Planning Department
Alan Varela, Director

June 3, 2024

**Re: General Atomics Office
14820 Central SE
Traffic Circulation Layout
Engineer's/Architect's Stamp 5-24-2024 (L23D011A)**

## A3 SITE PLAN

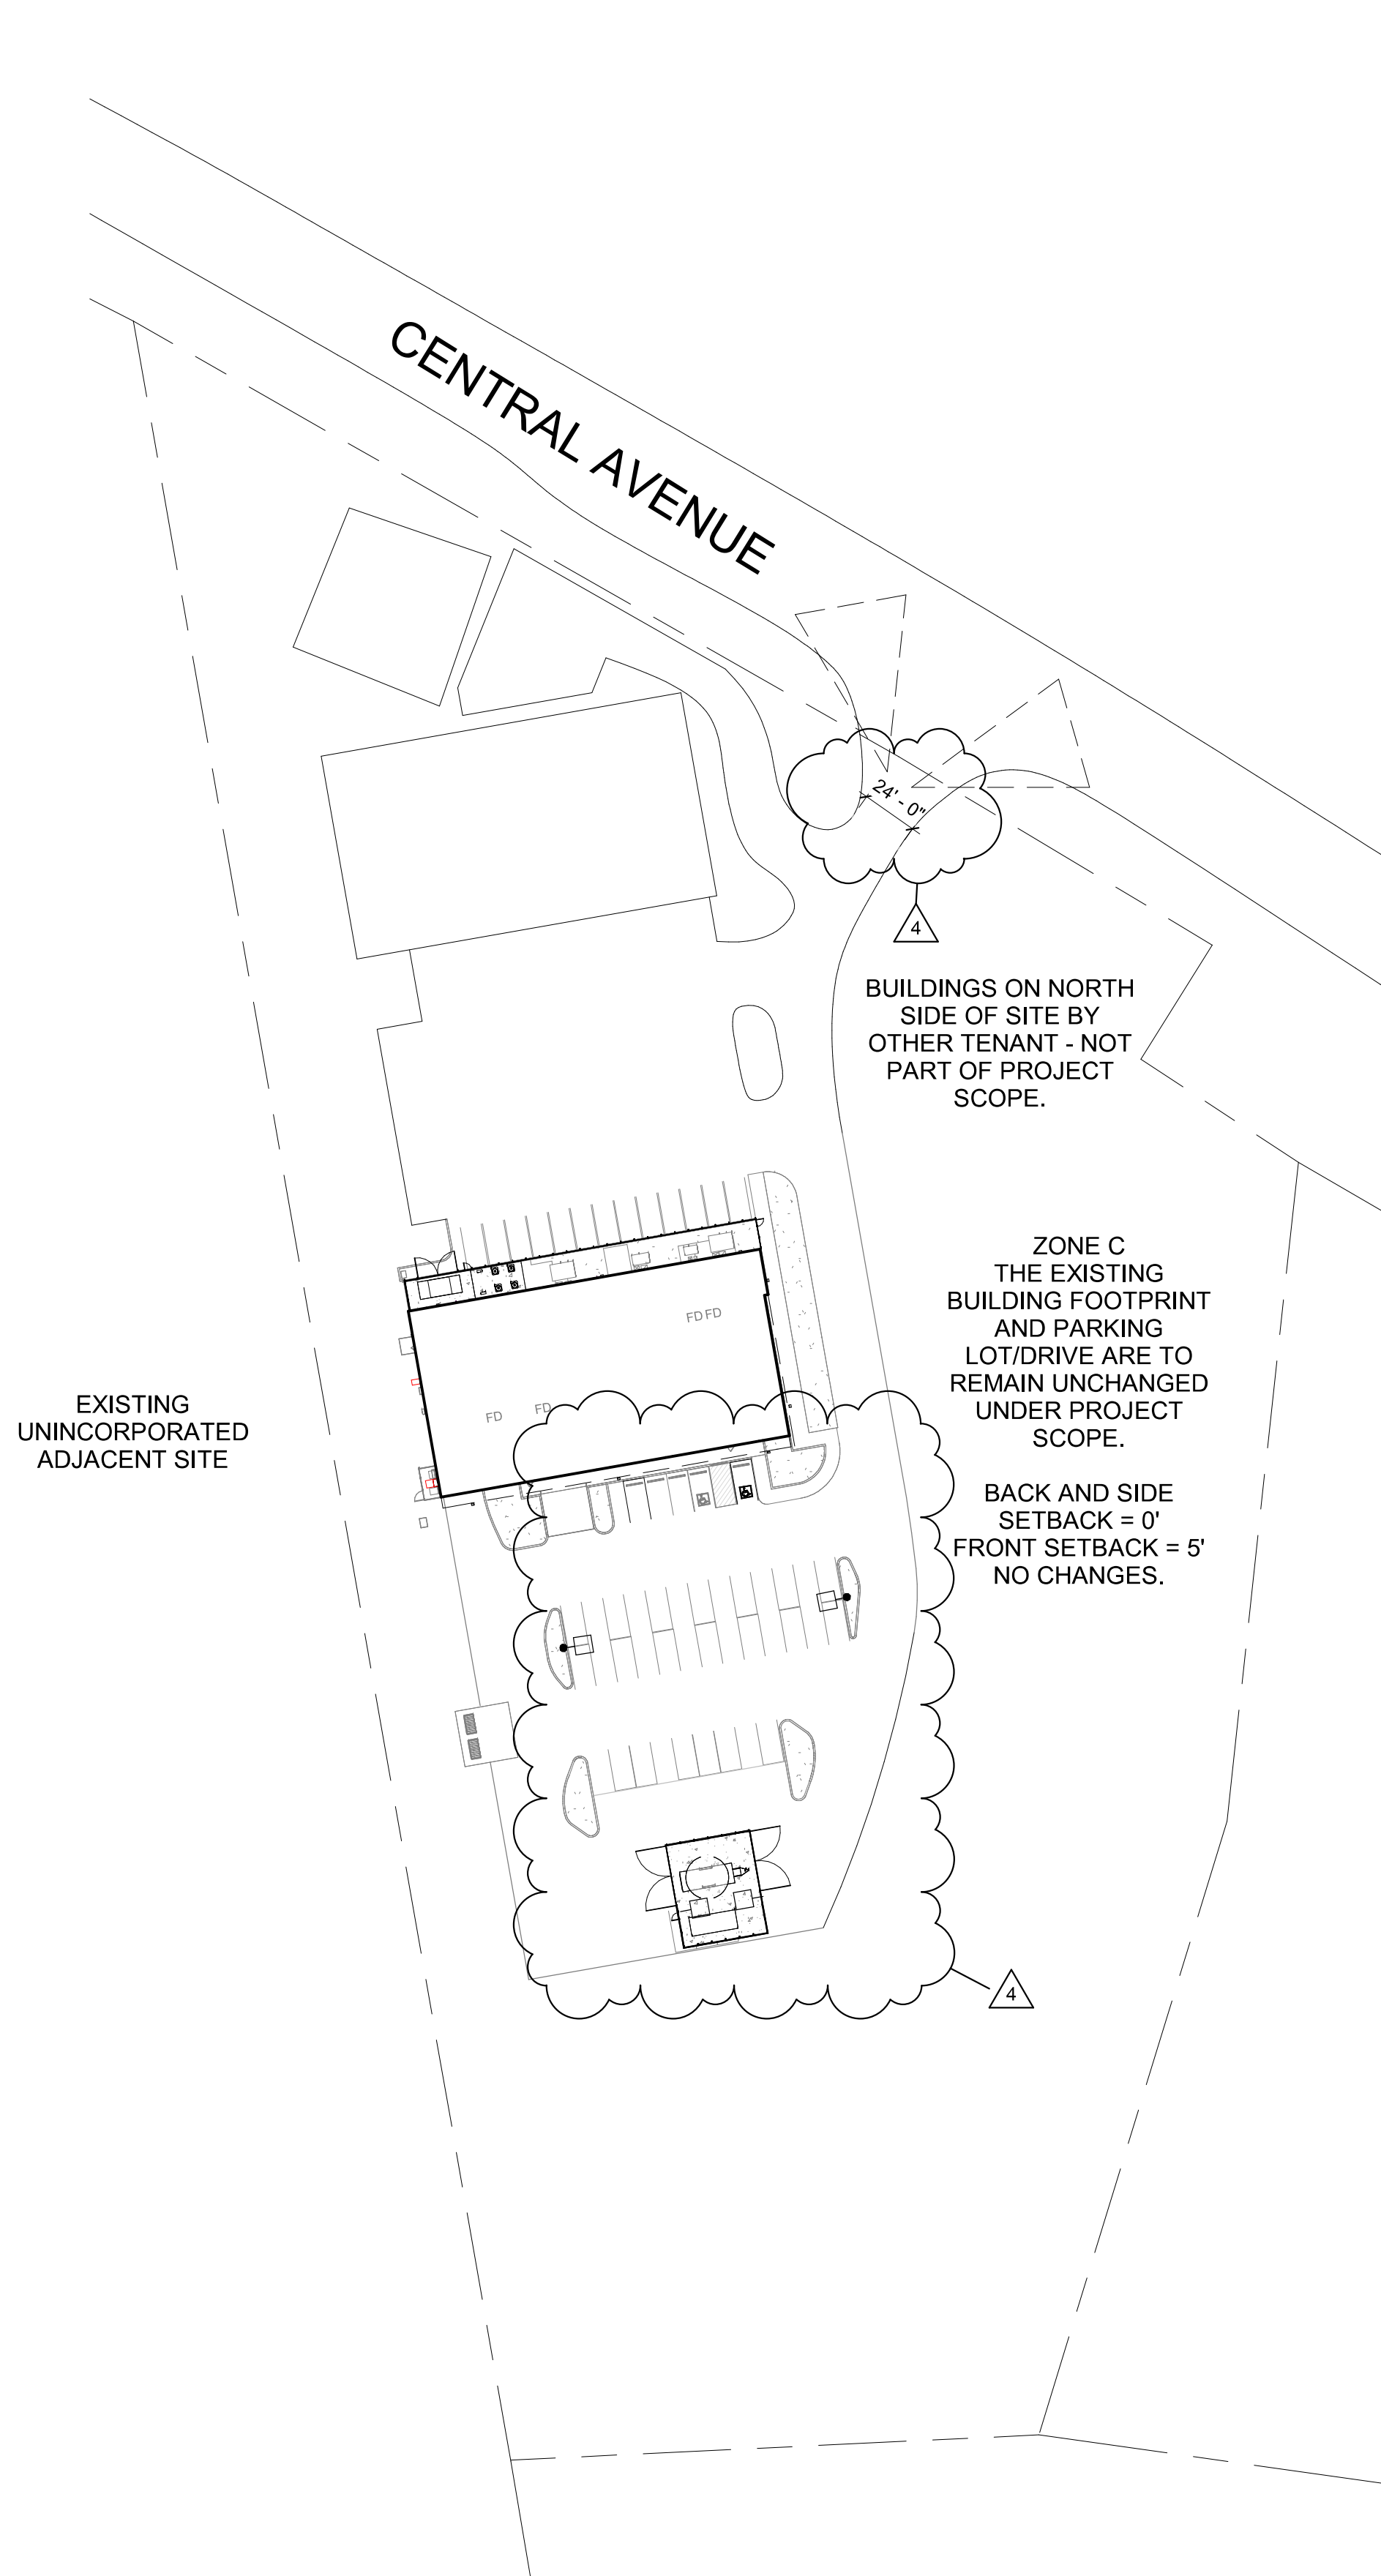
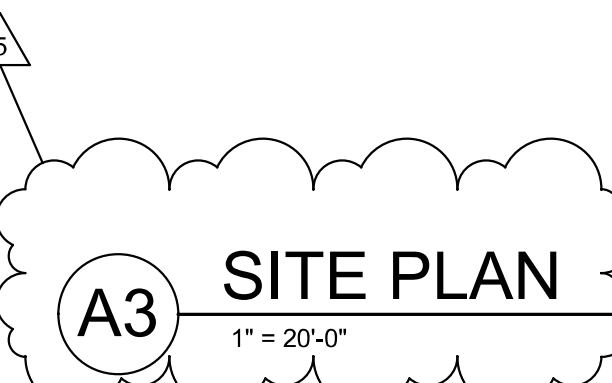
1. Please show a vicinity map on sheet AS101 showing the location of the development in relation to streets and well known landmarks.
2. In the parking list indicate that one of the two ADA spaces should be for van.
3. All accessways to the site from the adjacent roadway shall be ADA-compliant.
4. Please list the width and length for all existing and proposed parking spaces. Some dimensions are not shown.
5. The minimum parking stall dimensions are:

6. The ADA accessible spaces must include an access aisle. Van accessible aisles should be 8ft wide; all others should be 5ft wide.

7. ADA curb ramps must be updated to current standards and have truncated domes installed.
8. Motorcycle parking spaces shall be designated by its own conspicuously posted upright sign, either free-standing or wall mounted per the zoning code.
9. All bicycle racks shall be designed according to the following guidelines:
 - a. The rack shall be a minimum 30 inches tall and 18 inches wide. Show your details.
 - b. The bicycle frame shall be supported horizontally at two or more places. Comb/toaster racks are not allowed.
 - c. The rack allows varying bicycle frame sizes and styles to be attached.
10. Bicycle racks shall be sturdy and anchored to a concrete pad.
11. A 1-foot clear zone around the bicycle parking stall shall be provided.

12. Bicycle parking spaces shall be at least 6 feet long and 2 feet wide.

13. Show all drive aisle widths and radii. Some dimensions are not shown.

15. List radii for all curves shown; for passenger vehicles. Radius for delivery trucks, fire trucks, etc. is 25 ft. or larger.
16. Per the DPM, a 6 ft. wide ADA accessible pedestrian pathway is required from the public sidewalk to the building entrances. Please clearly show this pathway and provide details.
17. Per DPM, a 6 ft. wide ADA accessible pedestrian pathway is required from the ADA parking stall access aisles to the building entrances. Please clearly show this pathway and provide details.

20. All one-way drives shall have "One Way" and "Do Not Enter" signage and pavement markings. Please show detail and location of posted signs and striping.

21. Show the clear sight triangle and add the following note to the plan: "Landscaping and signage will not interfere with clear sight requirements. Therefore, signs, walls, trees, and shrubbery between 3 and 8 feet tall (as measured from the gutter pan) will not be acceptable in the clear sight triangle.
